DRB Project No: PR-2022-007617 Date: 02/08/2023 Agenda Item: #5 Zone Atlas Page: H-21

Application For: SD-2023-00056 – PRELIMINARY/FINAL PLAT (DHO)

REQUEST: ELIMINATE INTERIOR LOT LINE BETWEEN TWO EXISTING LOTS TO CREATE ONE NEW LOT, DEDICATE ADDITIONAL RIGHT-OF-WAY ALONG TOWNER AVE NE

**Sketch Plat for
 Lot 5-A, Block 90-A
 Snow Heights Addition
 Being Comprised of
 Lots 4 and 5, Block 90-A
 Snow Heights Addition
 City of Albuquerque
 Bernalillo County, New Mexico
 September 2022**

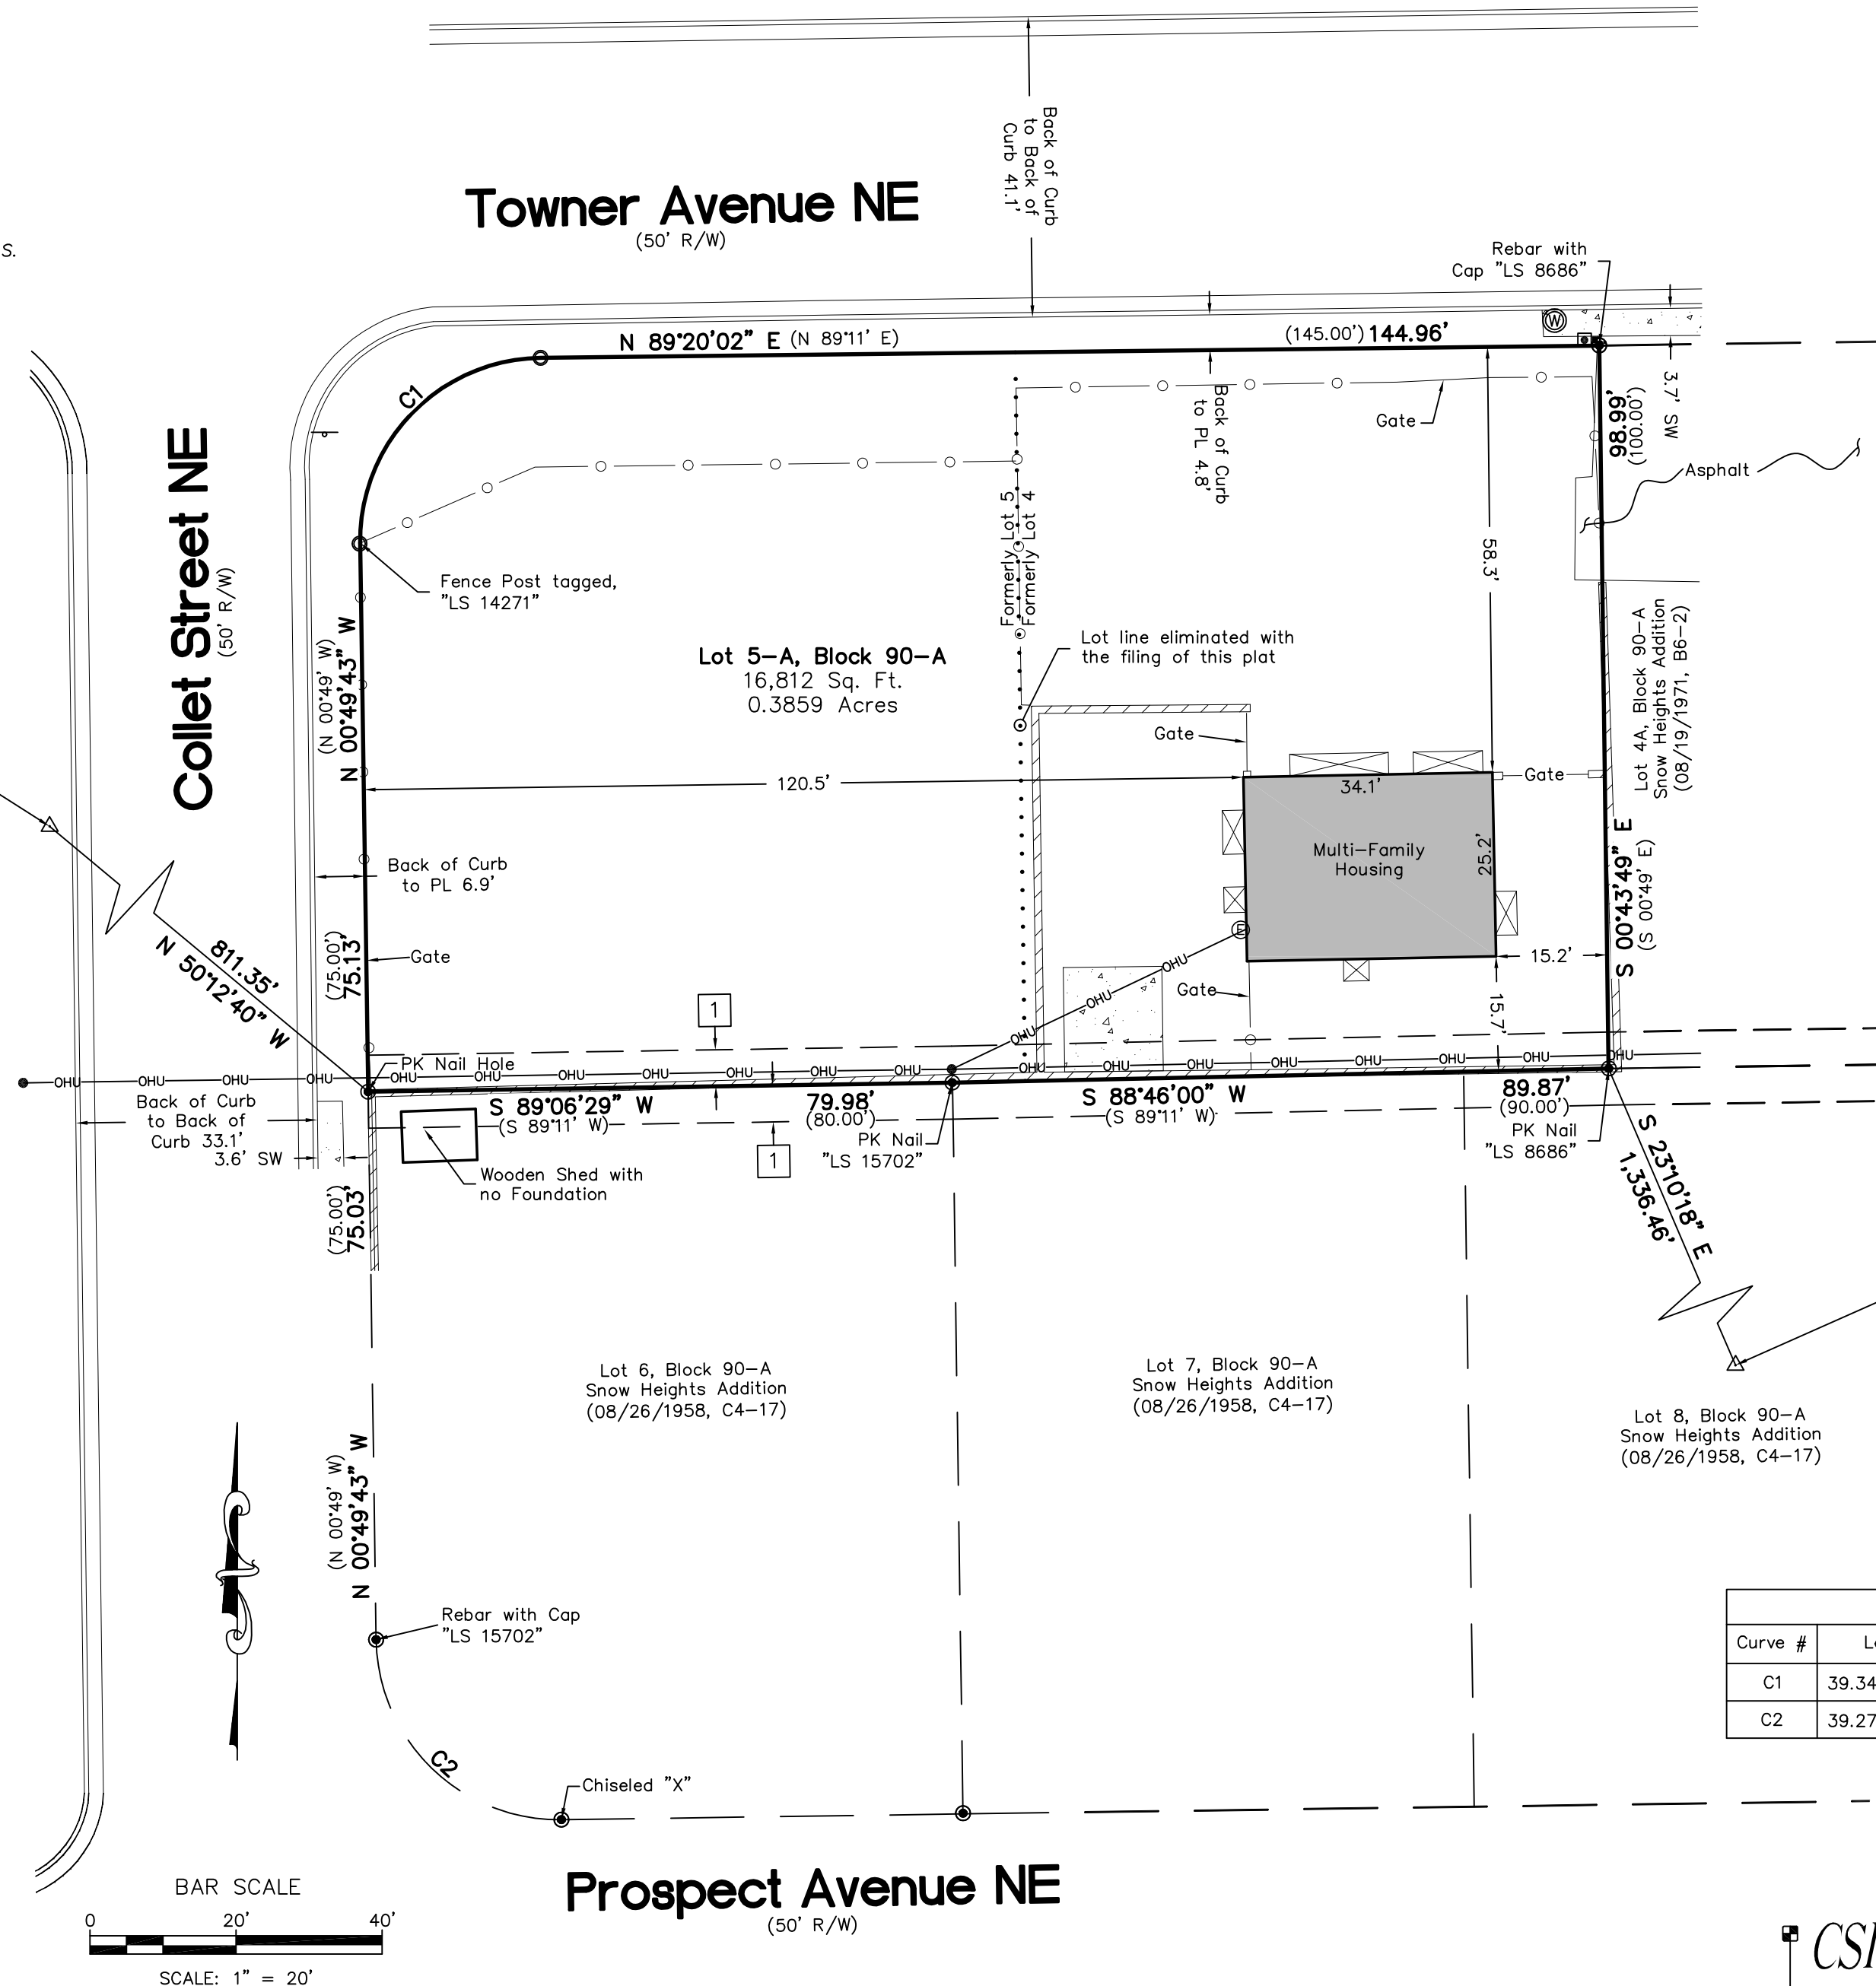
1. Property is zoned R-MH, and must meet all Dimensional Standards as per IDO 5-1(C), Table 5-1-1. Minimum lot width for R-MH is 150 feet. It is not clearly marked if that is being met on the plat shown.
2. Please clarify how the proposed lot is meeting this standard. Failure to meet the minimum width would require a waiver or deviation request be filed.
3. Code Enforcement has no further comments at this time.
